From: Anita Gardner
Sent: 05 December 2018 12:31
To: Planning.Responses
Subject: FW: LU/328/18/PL 90/91South Terrace, Littlehampton
Attachments: 955_90ST_P02.pdf

From: Anita Gardner [mailto:
Sent: 04 December 2018 11:44
To: Edmund T. Green 
Subject: LU/328/18/PL 90/91South Terrace, Littlehampton

Drawing Number:	955_90ST_D104	Revision:	*
Scale:	1:100 @A3	Date:	MAY 2018
		Drawn:	ETG

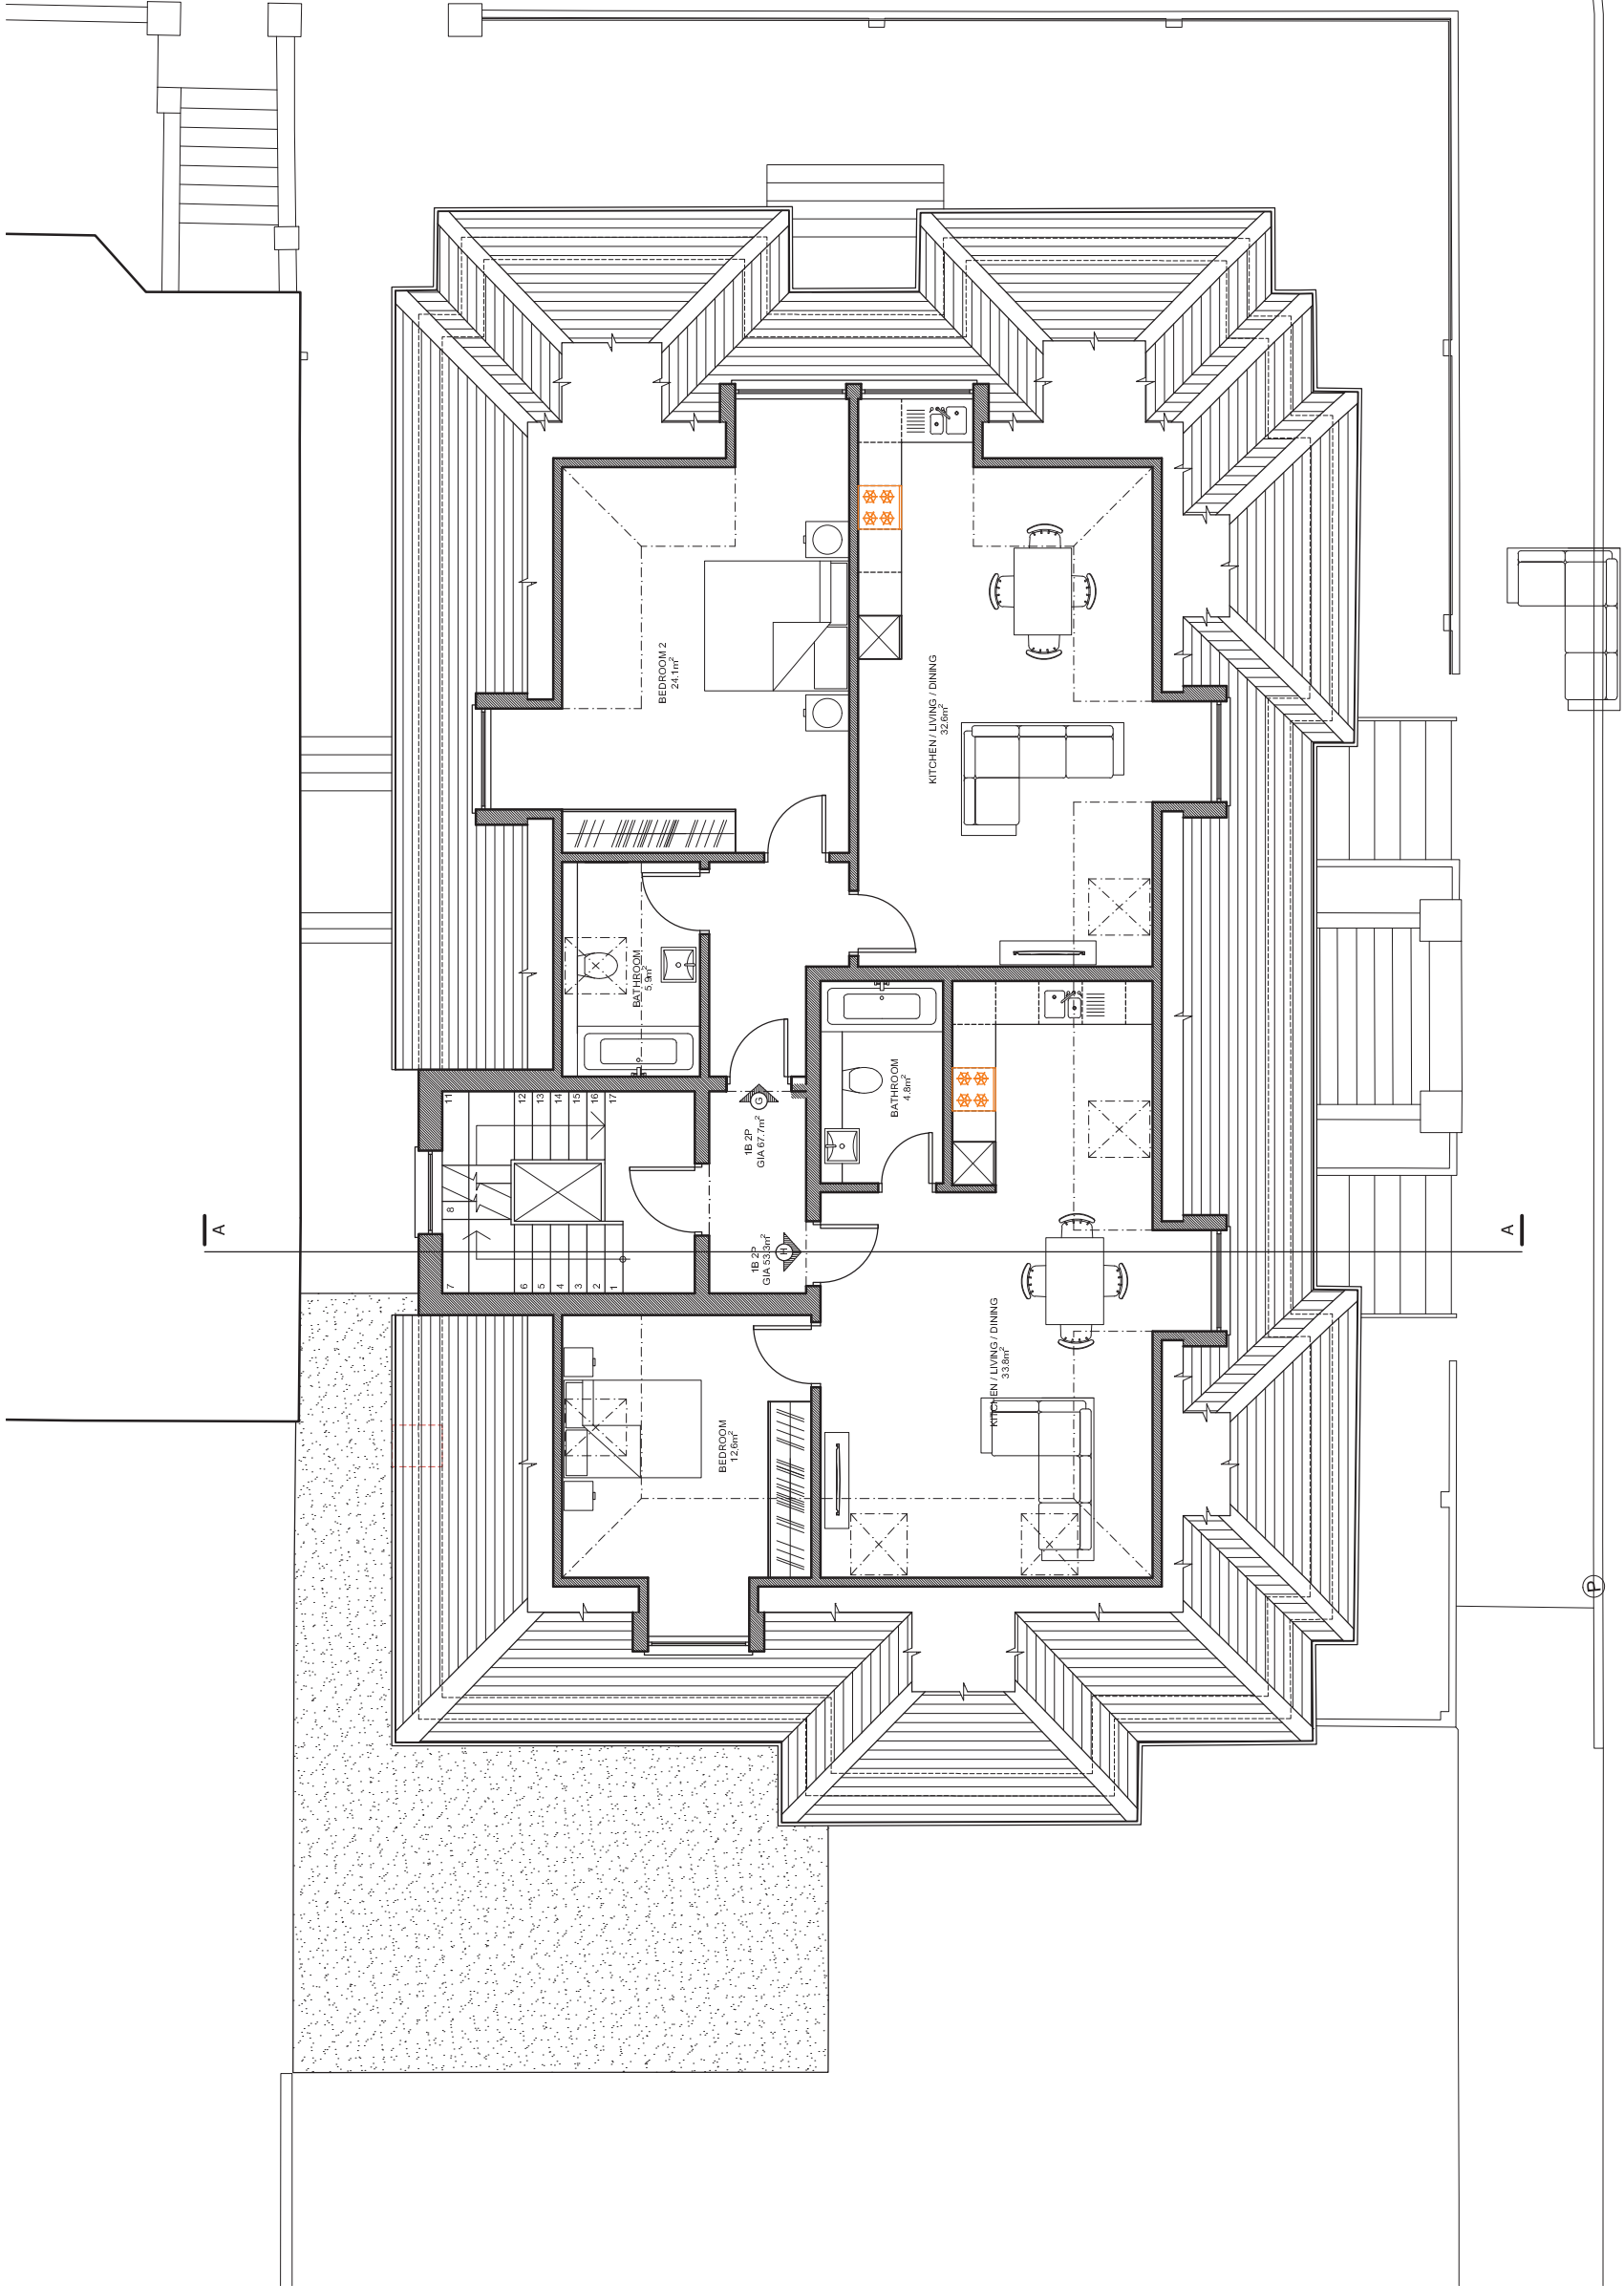
I have had preliminary discussions regarding your application with the Conservation officer today. It is noted that the North Elevation Proposed 955_90ST_x010 is incorrectly titled and should read Existing North Elevation and the Second Floor Plan refers to the bedroom to Flat G as the second bedroom when it is the only bedroom.

It is also apparent that the access to the roof terrace has been widened and is now visually more prominent in the street scene and adversely detracts from the Building of Character. The railings have also been deleted from the proposal and these made a positive contribution to the character of the area. Accordingly, without prejudice, these items should be amended/included within the submitted scheme.

Please find the amended drawings attached showing the drawing title/labelling errors corrected - thank you for drawing these to my attention.

In regards to the roof terrace access; the width shown in our proposal is the same as was the shown in the previously submitted plans. I now note that the plans and elevations submitted under the previous application do not correspond to one-another. If you measure off the plans you will see that the proposed width is approx. 3.4m, which we have replicated in this application.
